Application: SSI 7485

I write regarding the proposed modification to M4-M5 Link, Mod 2 The Crescent overpass and changes to pedestrian infrastructure in North Annandale, Rozelle and Rozelle Bay Foreshore area.

Figure 4-2 Pedestrian and cyclist bridge infrastructure options

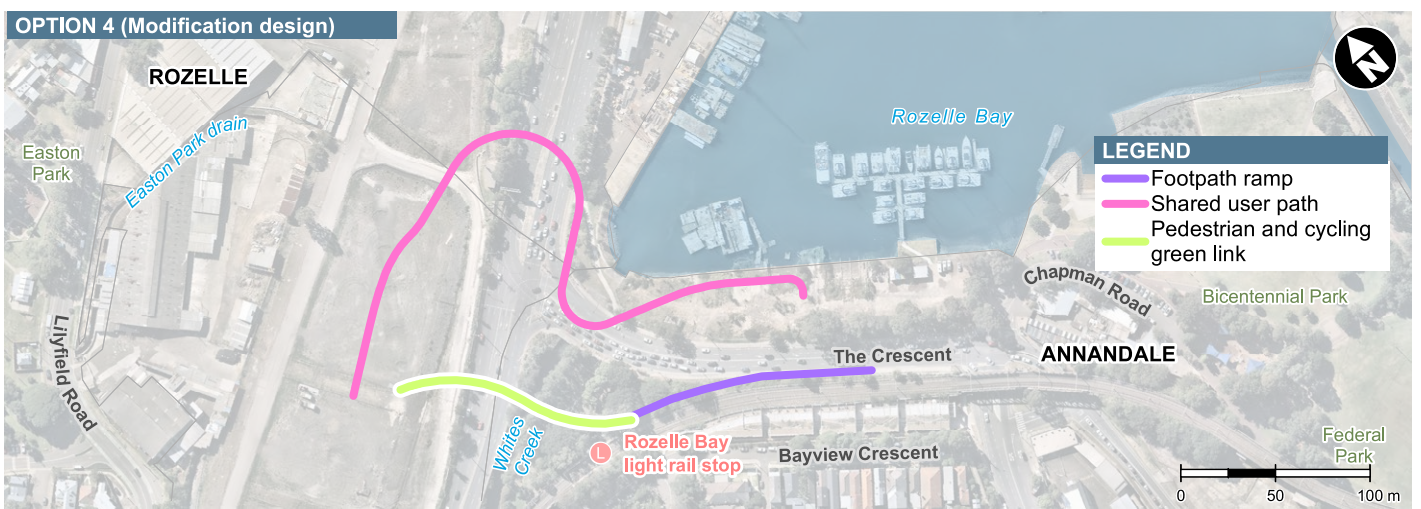
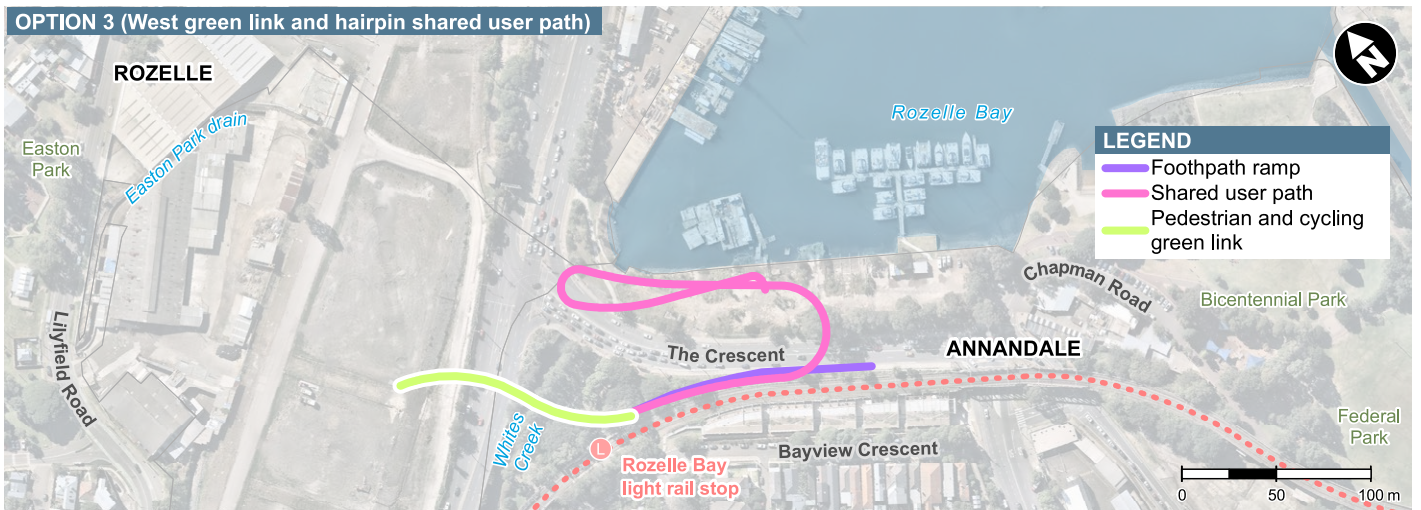
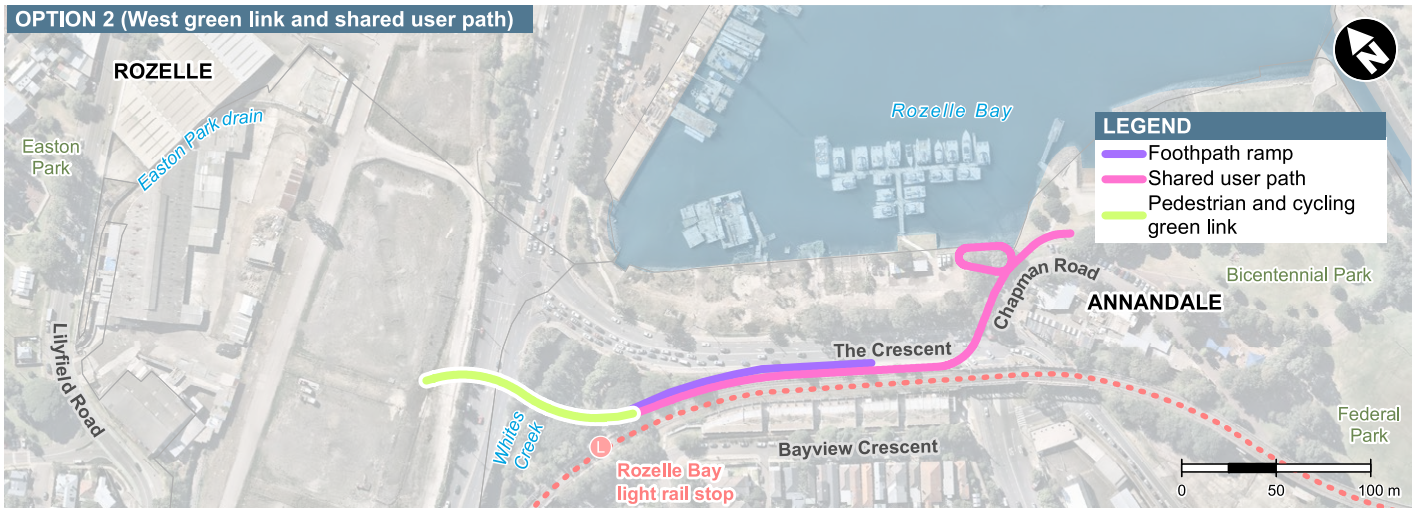
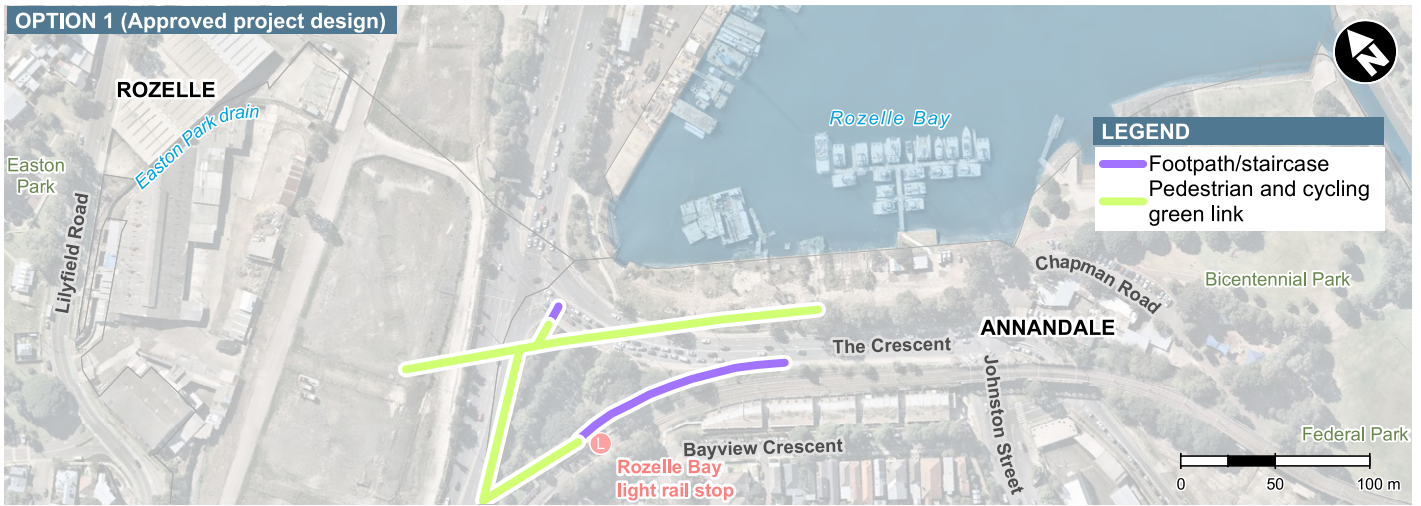
I request RMS work with the community to explore alternate design options to the proposed new car overpass design and the changed pedestrian and cyclist links. I am seeking the reinstatement of the safe, direct access from the approved EIS GreenLink to create a continuous green open space connection from the Rozelle Rail yards and Annandale to the foreshore. The GreenLink was more than just a walk way - it put people central to the design, maximising safety, and providing much needed accessible open space for the community now and into the future Bays Precinct design.

- The significantly reduced safety and increased risk for pedestrians and cyclists with removed access over The Crescent to Bicentennial Park and the increased traffic along Johnson Street.
- Being required to cross five sets of pedestrian lights at The Crescent as my option to reach the foreshore from Annandale or from Rozelle Bay light rail stop.
- Removal of direct active links to the foreshore, cutting the community off from the area and the proposed revitalisation of the entire Bays Precinct, including linking the Light Rail and Bus stops to a Ferry wharf and Metro station.
- Urban and landscape design that is being built before a finalised Masterplan for the area.
- Traffic changes that limit movements around the suburb and create further congestion in the local streets of Annandale, Forest Lodge, Glebe, Lilyfield and Rozelle with no planning to deal with these.

- Reinststate the GreenLink connecting communities and green open space from Rozelle to Bicentennial Park
- Relocate and design pedestrian and cyclist connections that are continuous, safe and direct.
- Design the modification infrastructure and active links in response to the character of the suburbs, the location of the foreshore and it's potential future development.
- Provide pedestrian and cyclist paths that maximise people safety and do not force them onto busier streets, unsafe concrete plazas and caged walkways.
- Integrate active and direct connections to all active transport - including the future Metro West and Foreshore Ferry Wharf
